**cPort Credit Union 50 India St., BP# 2017-01518**

Below are my responses per our conversation yesterday.

**A922**

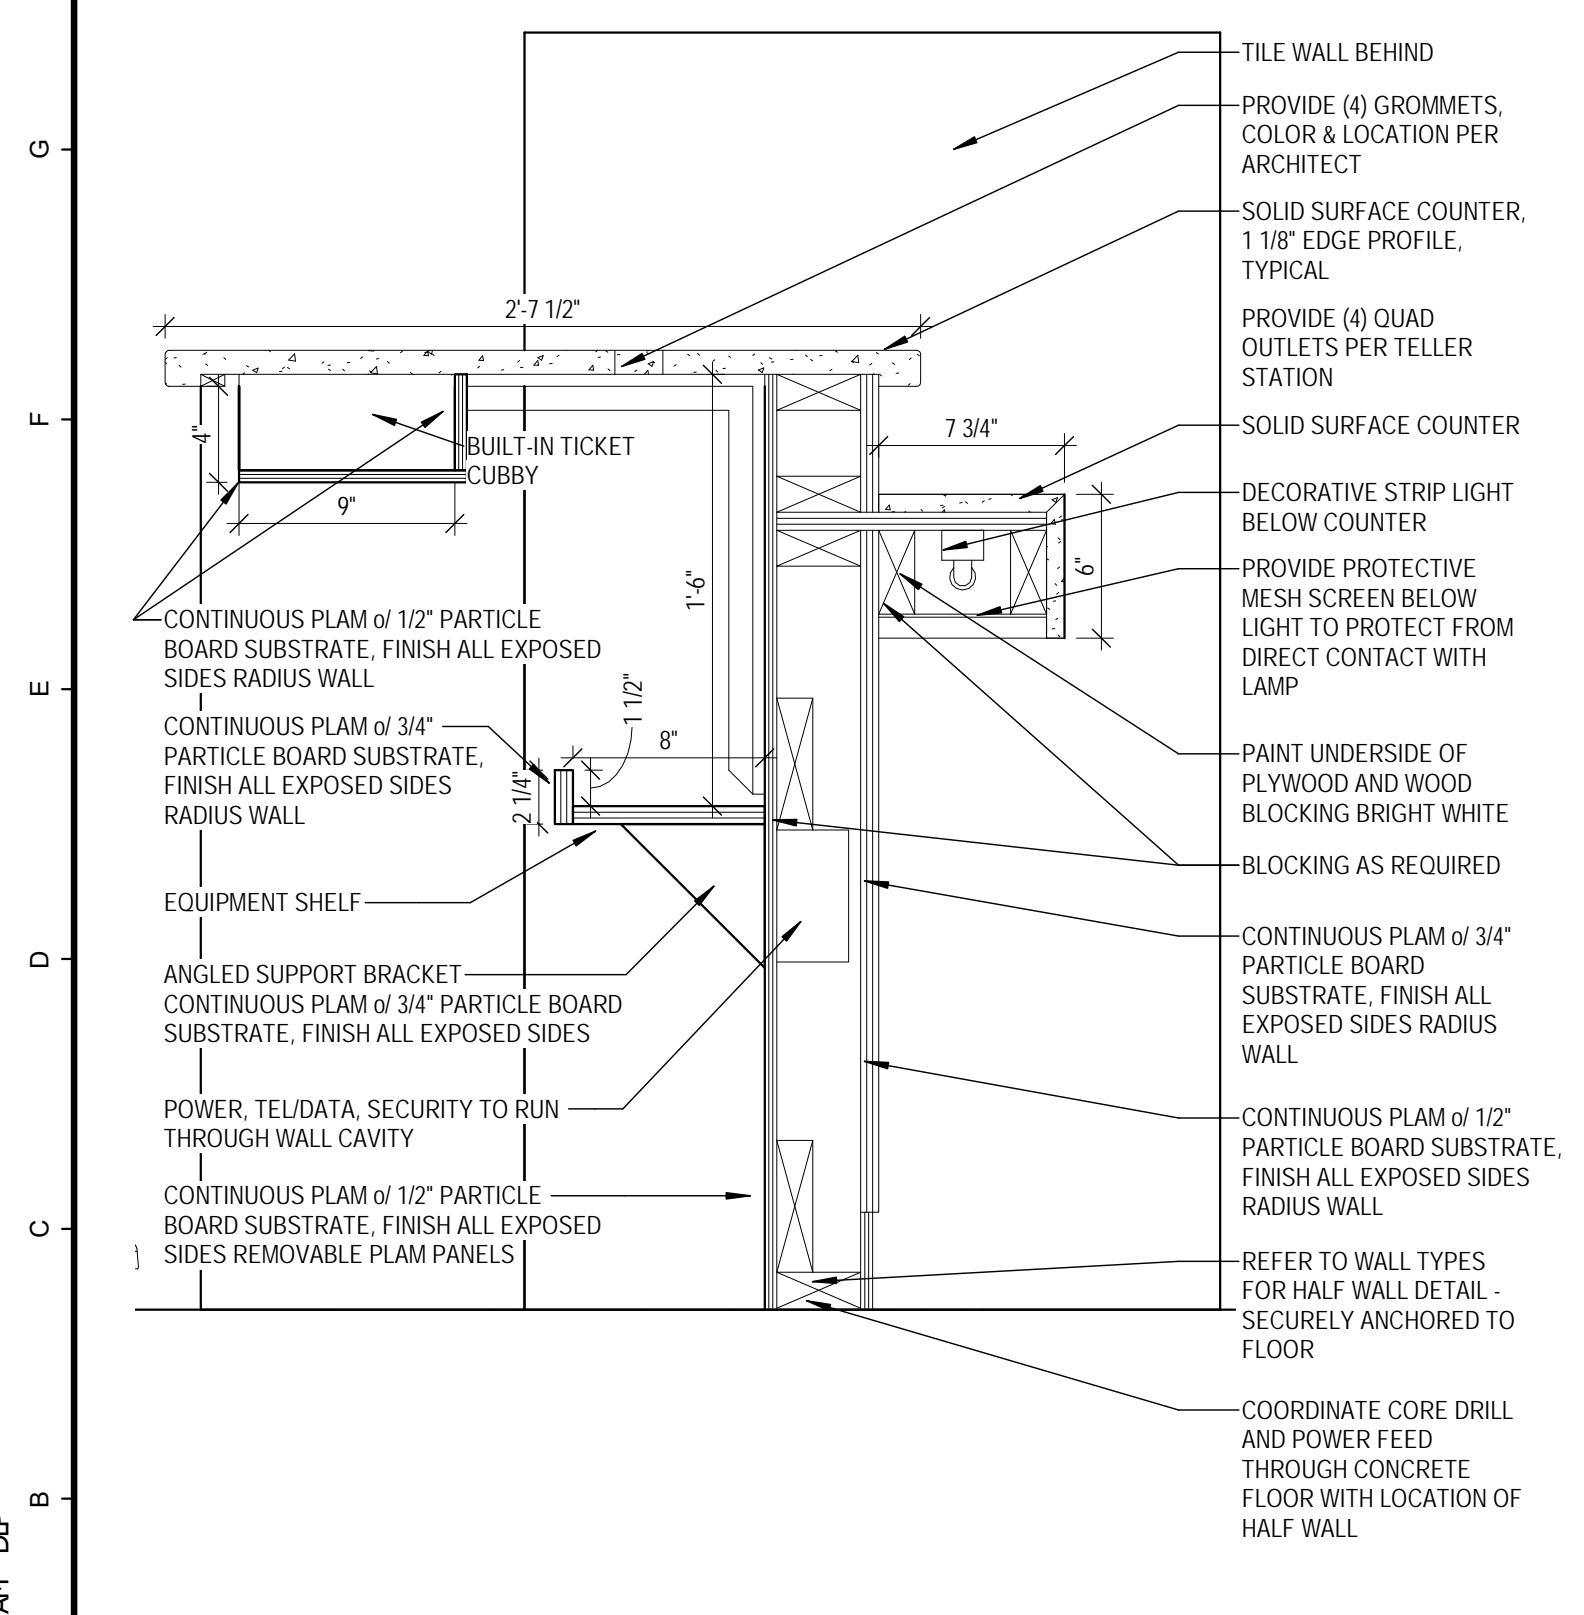
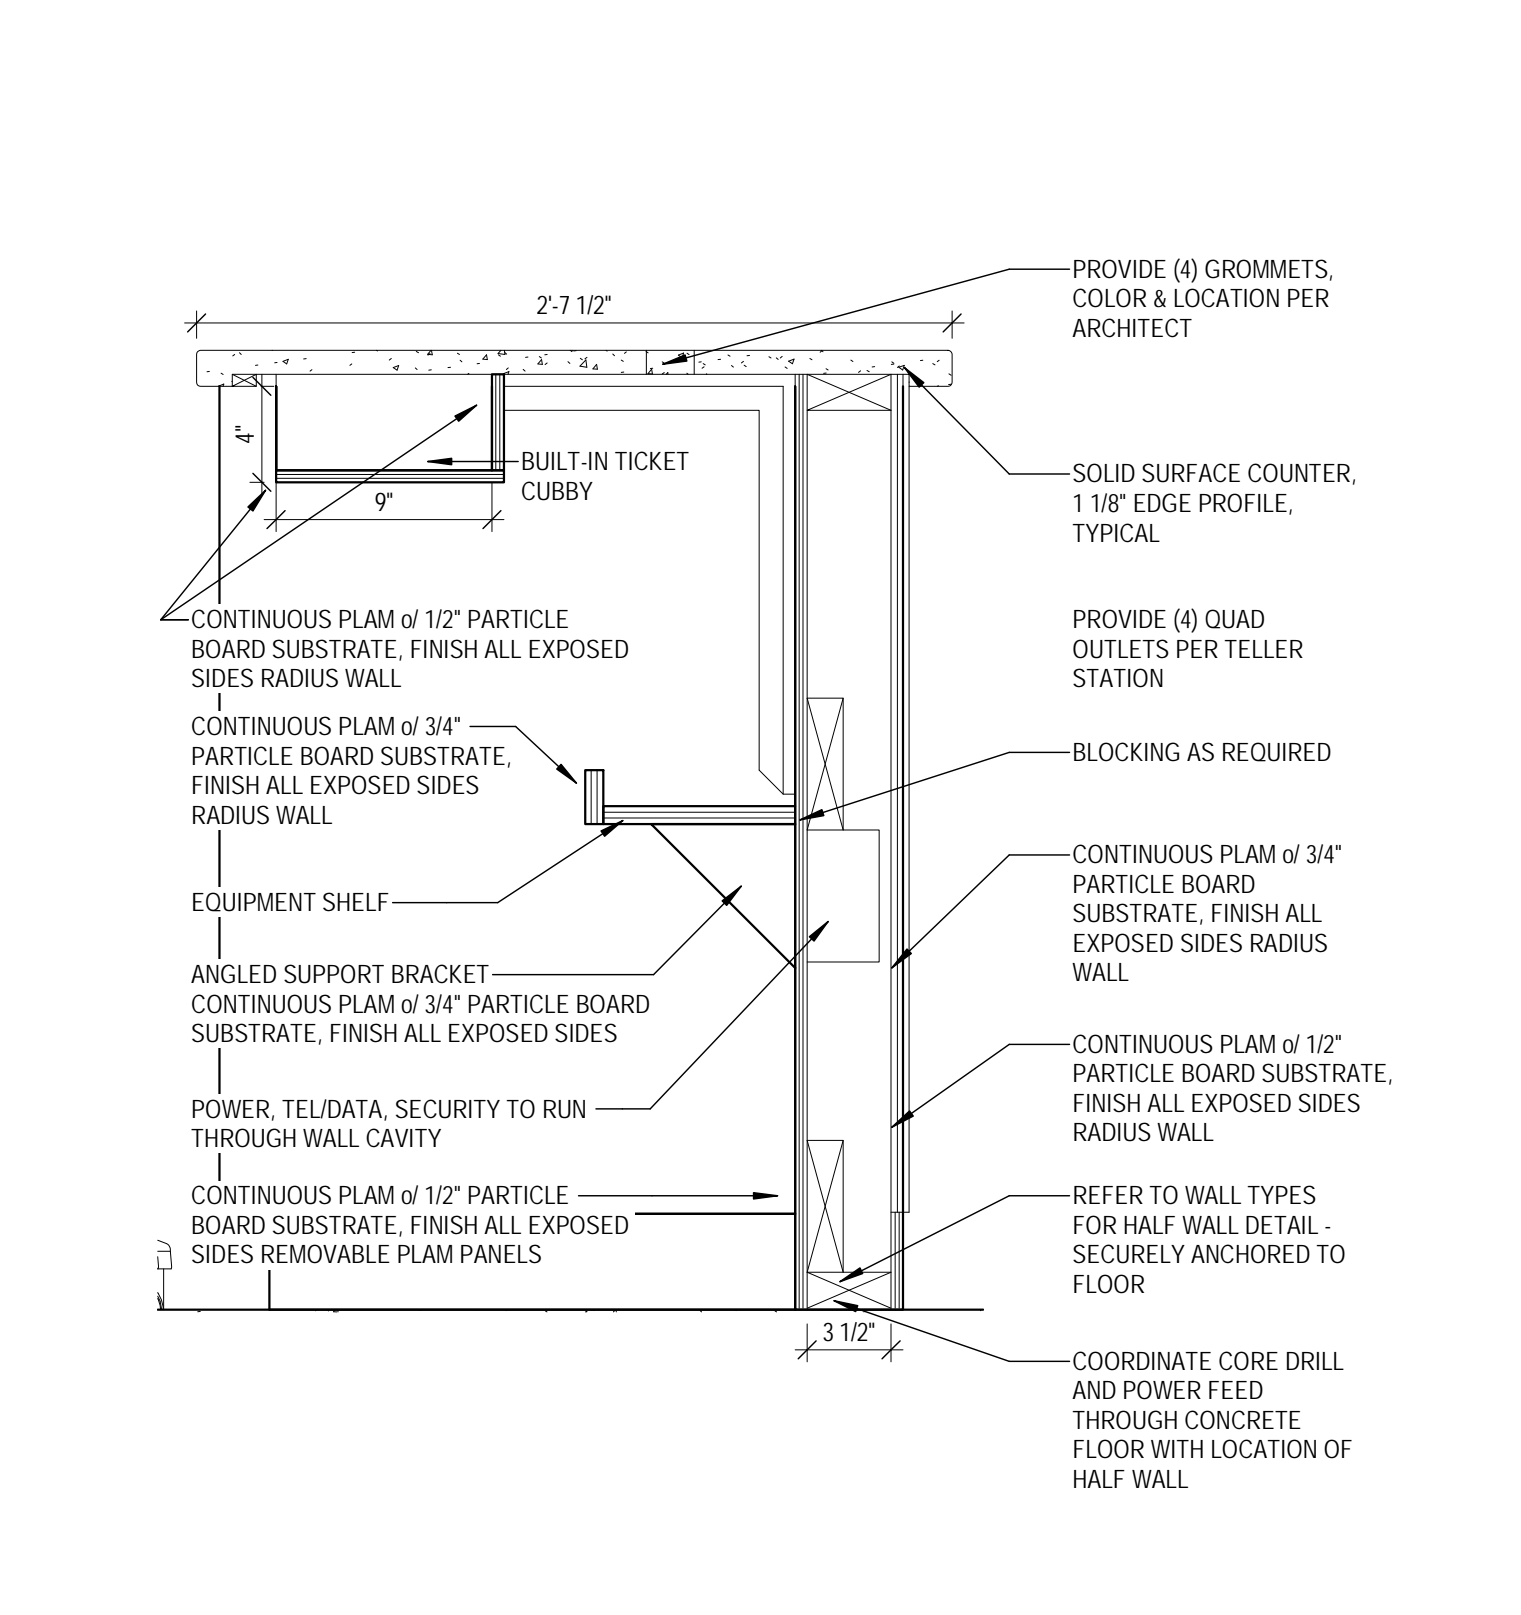
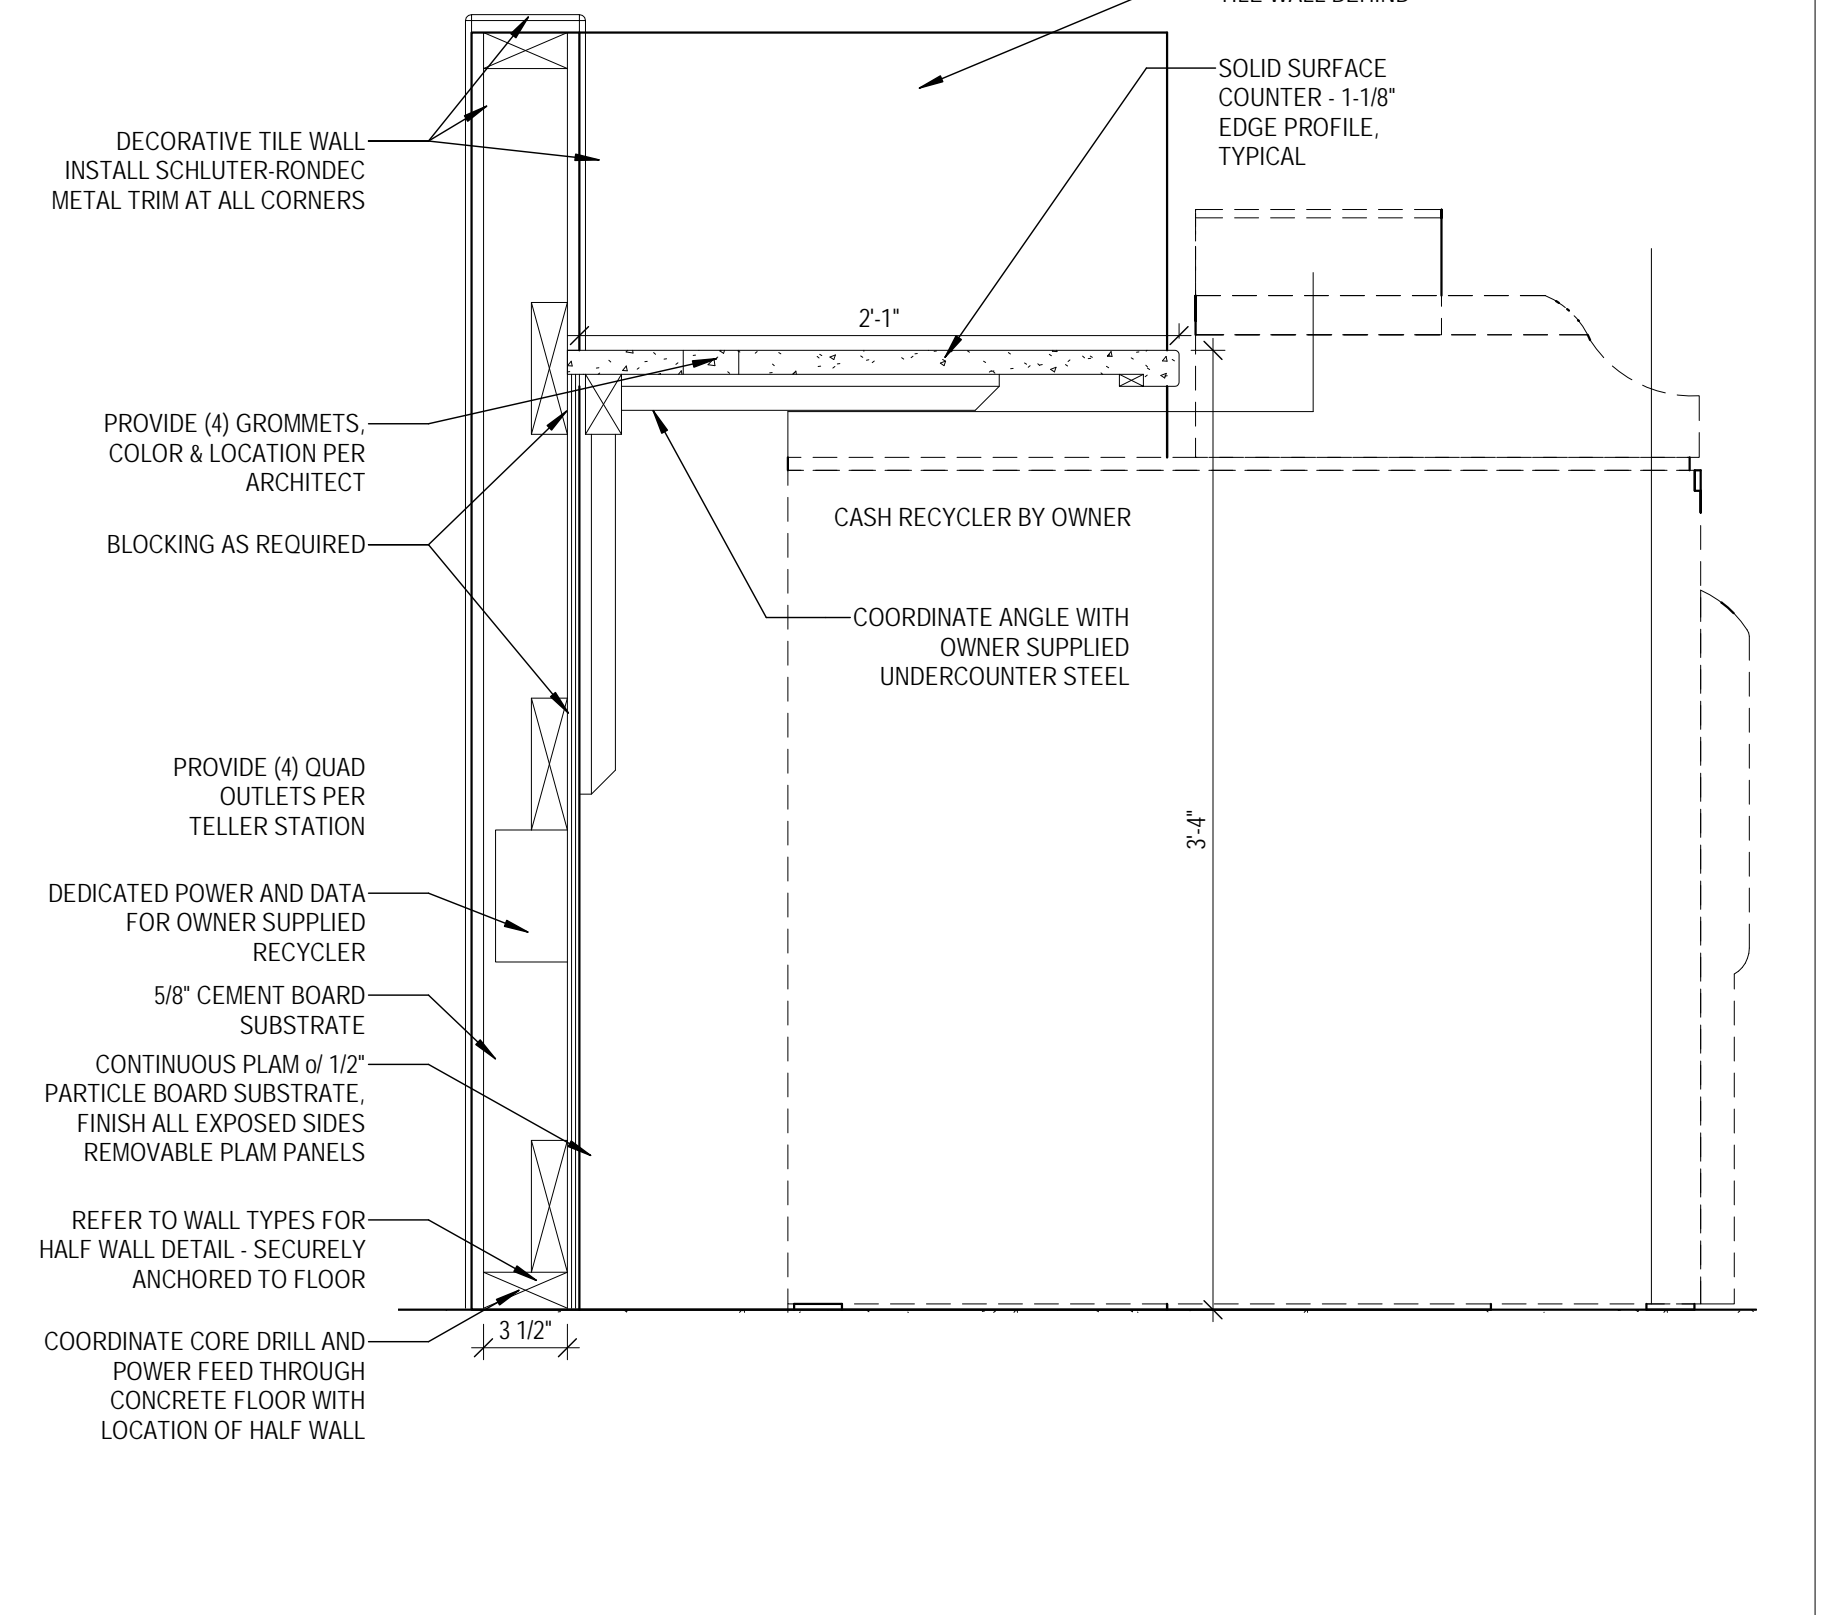
Sheet A922 – both locations provide ada accessible height transaction surfaces
